Pre-application advice

Application No: PRE2023/00067

Address: 132 Kings Road, Brighton

Proposed Penthouse Roof Addition and Lift Shaft.

TITLE: PROPOSED ELEVATIONS

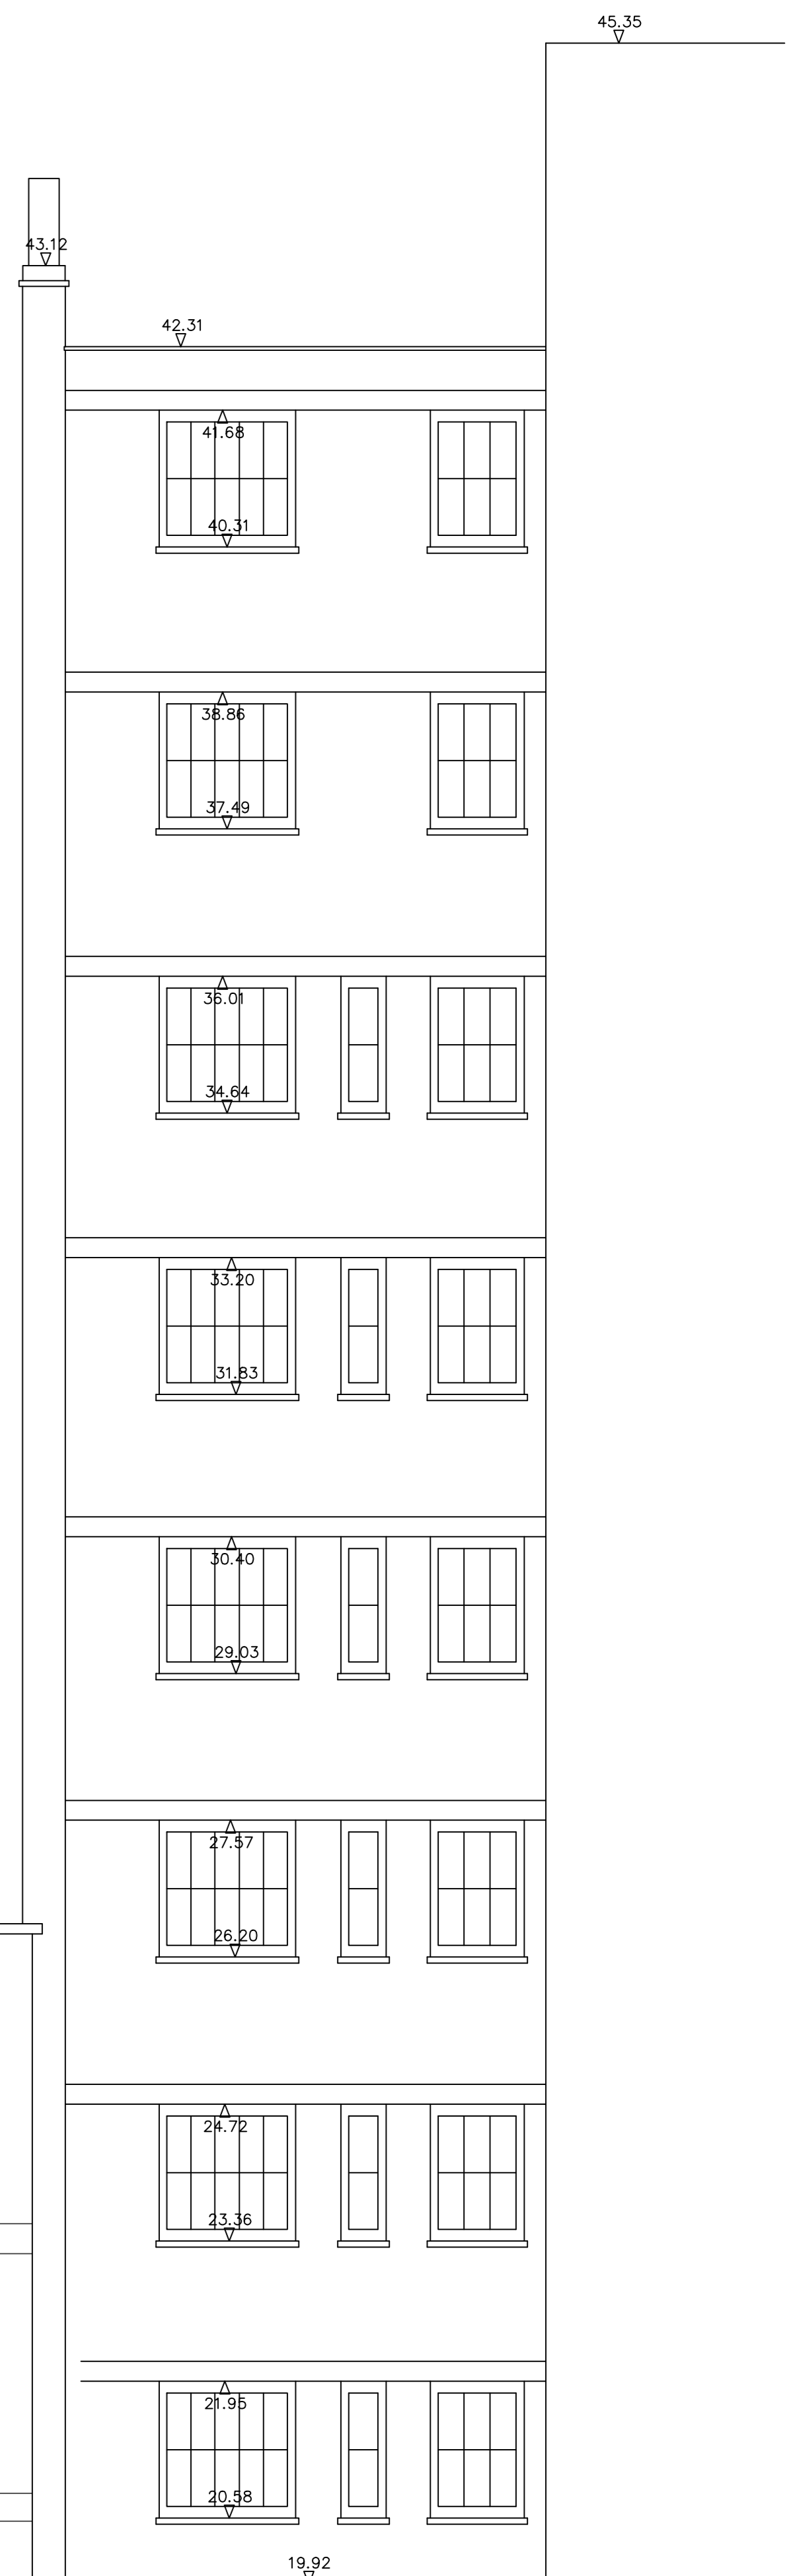
statement and drawings assessing the potential harm to the listed building. This will be most relevant on the rear extension for the lift shaft is proposed. This will sit up against the wall of the II* listed building and needs to be fully detailed and justified.

The lift shaft is to the rear of the building and will not affect primary views of the building from within the conservation area however there will be some visibility of it from the rear from the rear elevation of other properties, including listed buildings in Regency Square so it will most likely affect the setting of those. The lift shaft is also considerably taller than the rest of the proposal, projecting above the roof. It is set well back so should not be visible from the conservation area but will be from the rear of many listed buildings. For this reason, the lift shaft should not include an overrun above the roof level.

An application should assess the visibility of the extension from ground level by showing sight lines from both sides of Kings Road and the design of the extension would be more acceptable the more visually lighter weight it is. A purely glass structure with no visible masonry above the glazing would be preferable and the roofline would appear as uninterrupted reflection of sky against a background of sky. Too much visible bulk visible from the street may prove unacceptable.
